**Application by Fosse Green Energy Ltd for an order granting development consent
for the Fosse Green Energy solar farm**

**Deadline 5A –
Comments on documents submitted by
the Applicant at Deadline 5**

North Kesteven District Council

12th May 2026

Proposed Permissive Paths Plan

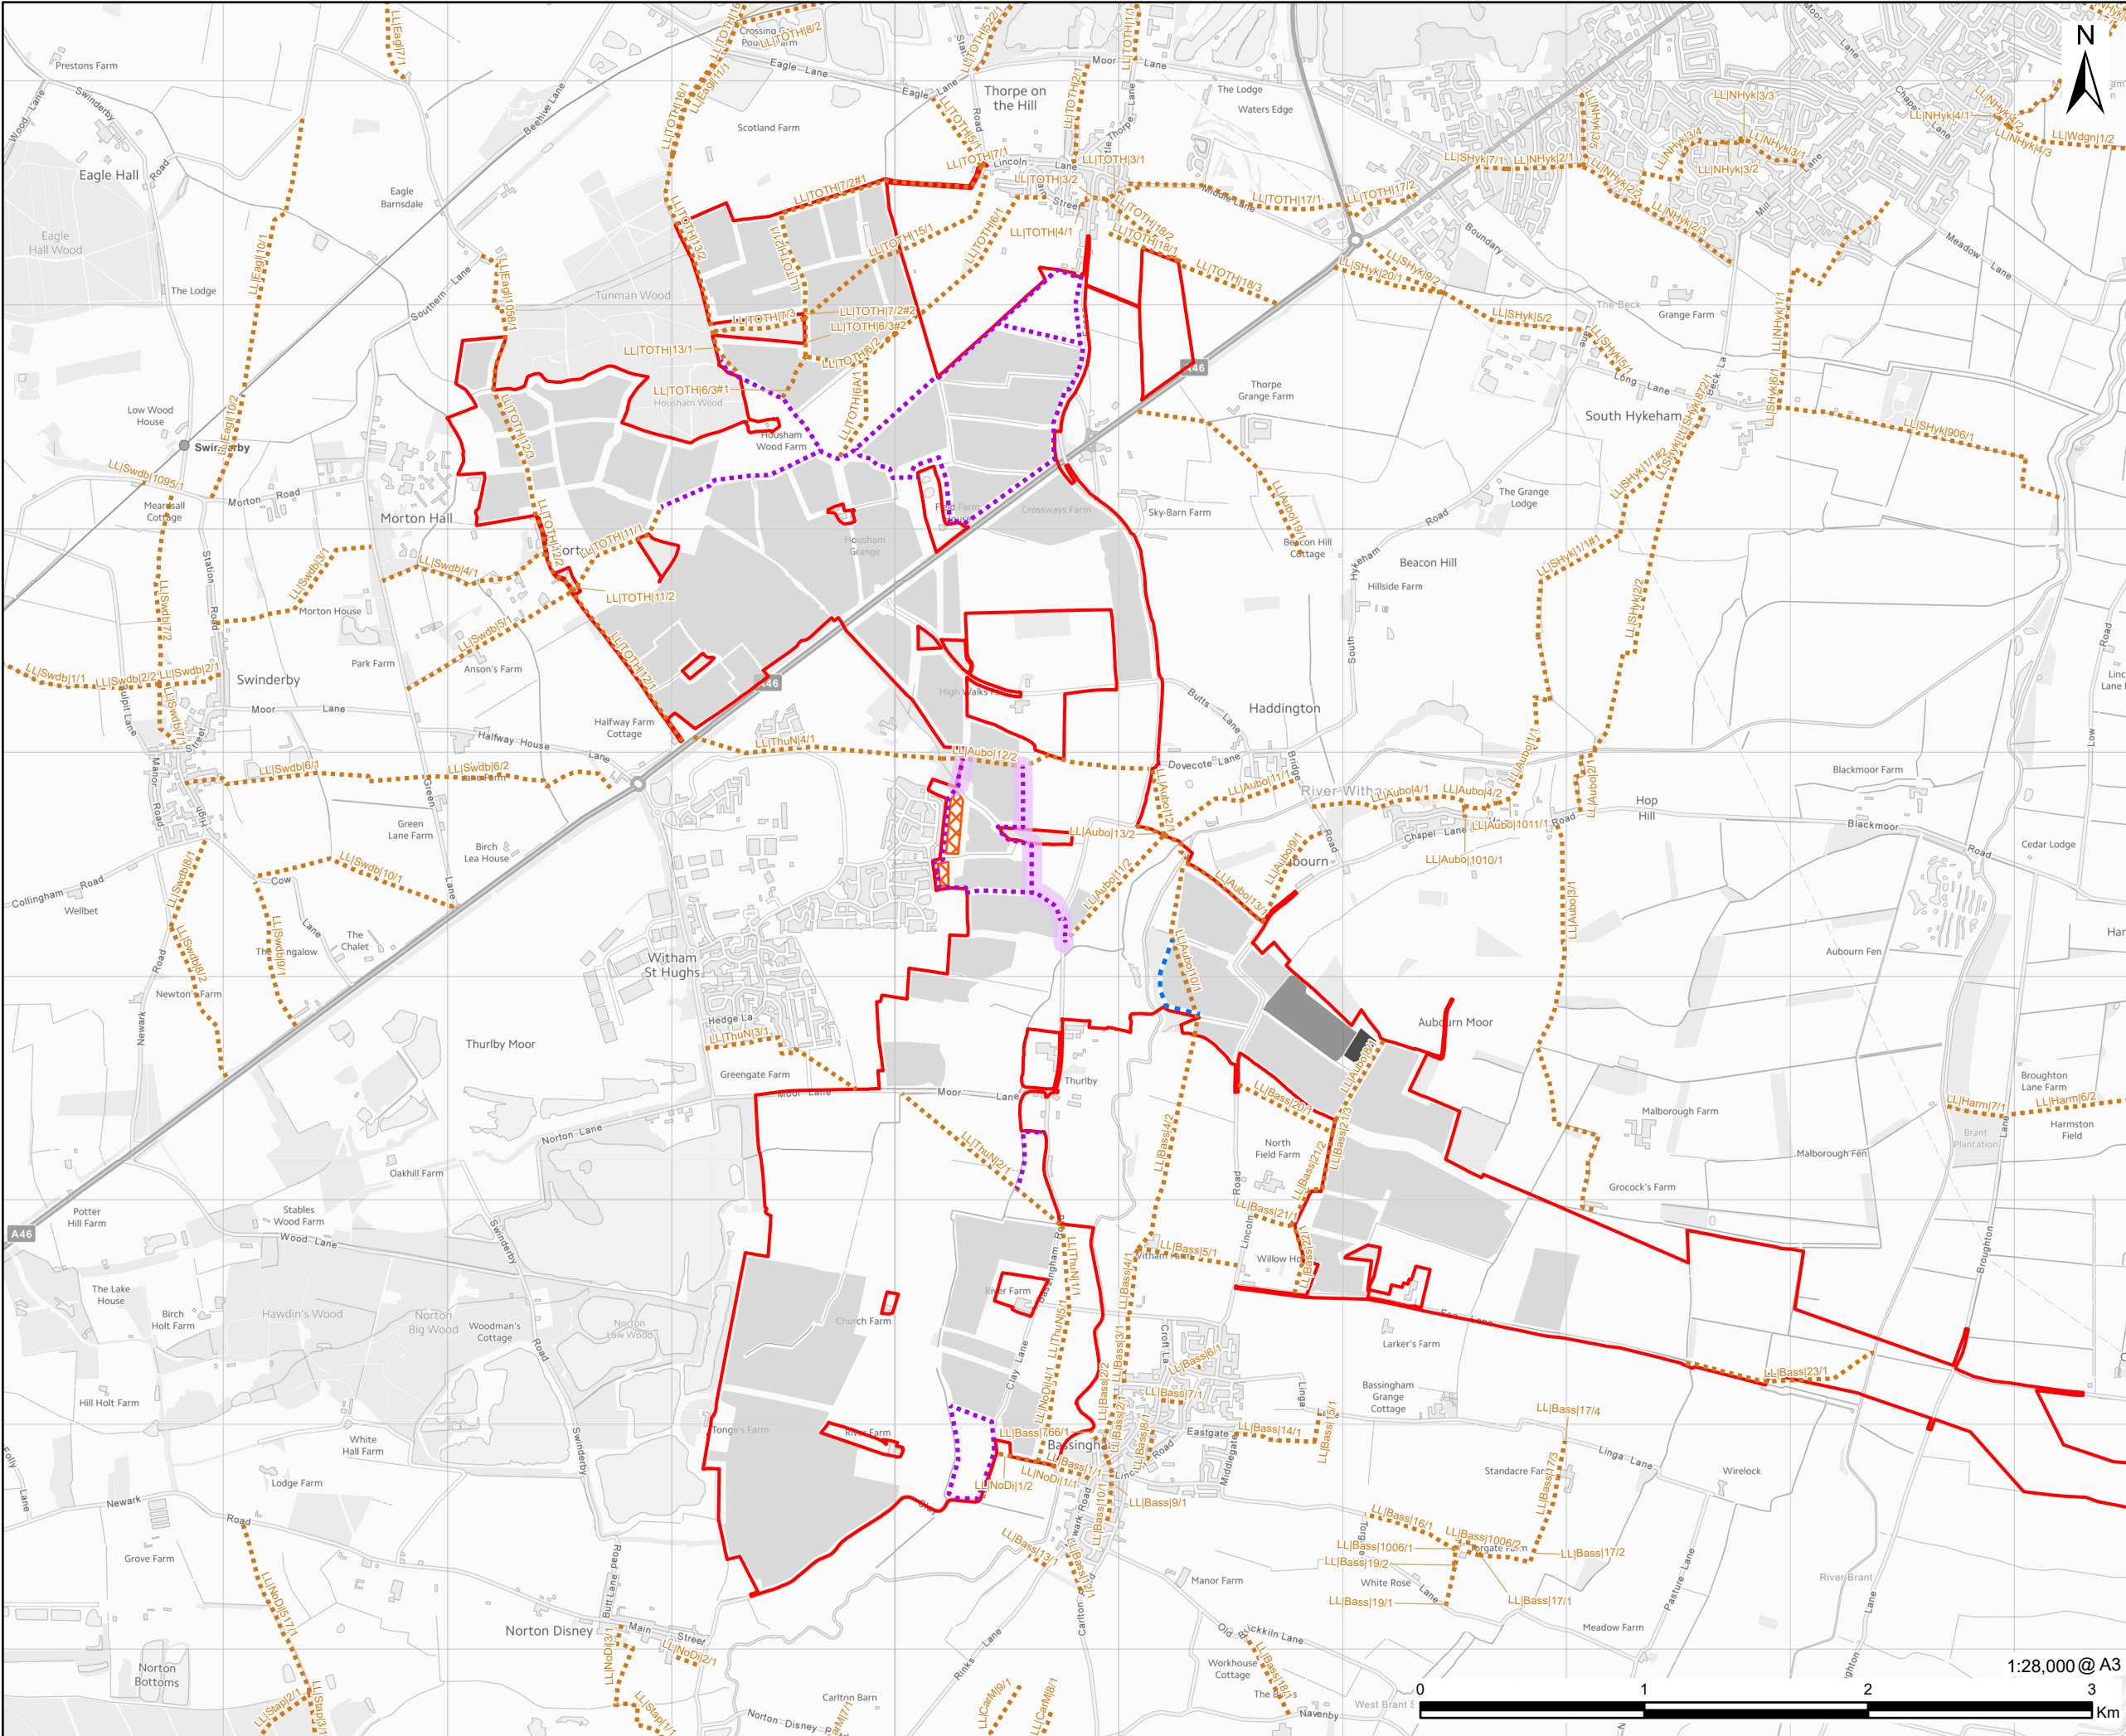
9. On the Landscape Mitigation Plans the permissive paths are not always shown in a clear and consistent manner. For instance, for the permissive path which would lead to The Avenue at Morton on Sheet 3, it is difficult to identify its route, which on close examination is a continuous pale pink / purple line – whereas the key shows permissive paths shown by a dashed line.
10. The Council therefore asks the Applicant to review how the proposed permissive paths are shown on these drawings.
